OXFORDSHIRE COUNTY COUNCIL'S RESPONSE TO CONSULTATION ON THE FOLLOWING DEVELOPMENT PROPOSAL

Application no: 21/02083/REM

Proposal: Reserved matters application to 18/00792/OUT - for the demolition of existing buildings and erection of up to 46 no. dwellings, with associated works and provision of open spaces

Location: Land at Tappers Farm, Oxford Road, Bodicote, Banbury

Figure 4: Proposed Foul Water Network

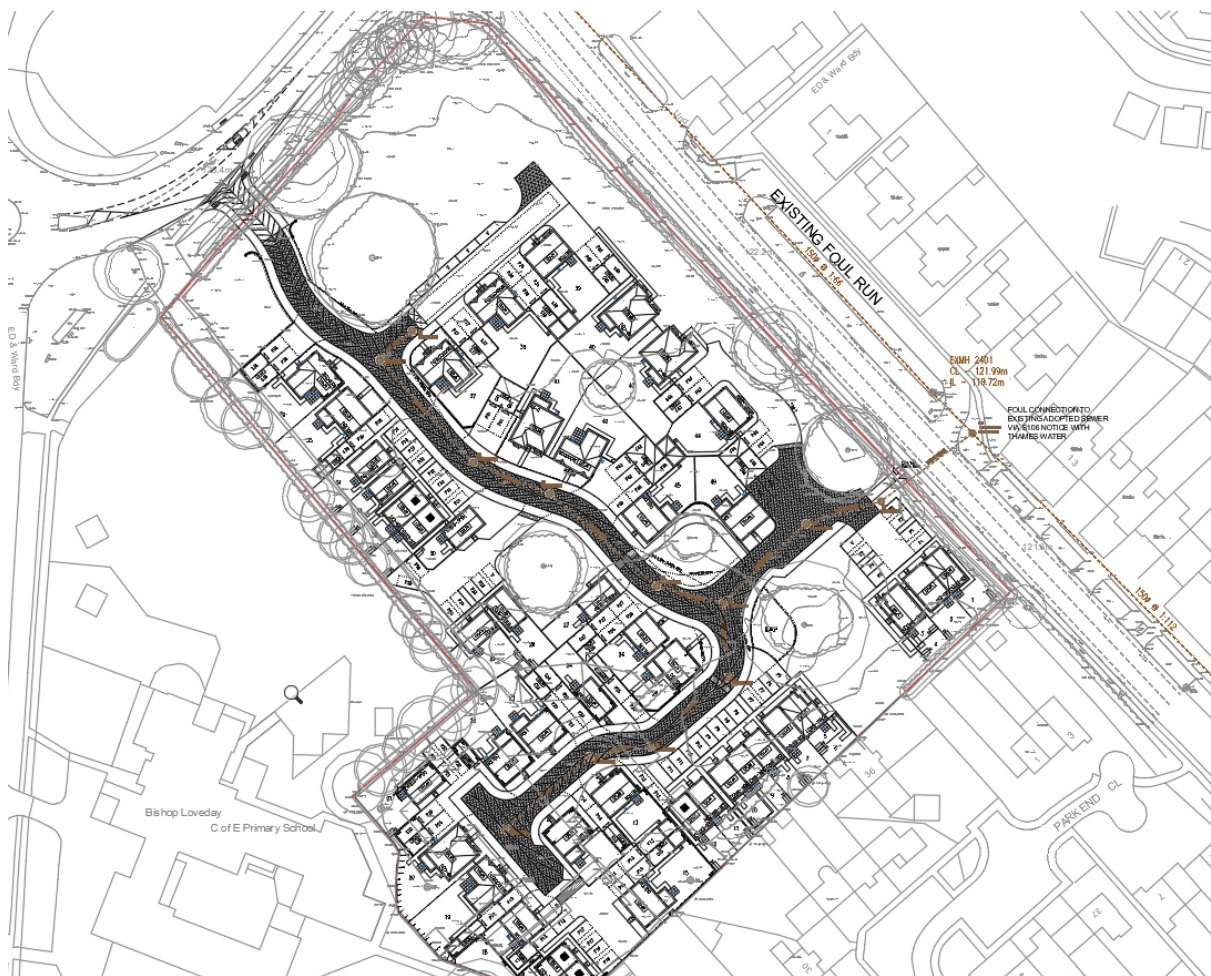
No updated FRA or drainage strategy provided to address previous LLFA comments in this submission.

Where calculation shows Total Area (ha) 0.020, this must be reflected on the drawing. Where was this figure derived from? If this is the area of infiltration, this must be shown on the drainage drawing. Where runoff is to be infiltration on private plots, this must also be shown in the drawing.

Drawing must also show the exceedance flow routes.
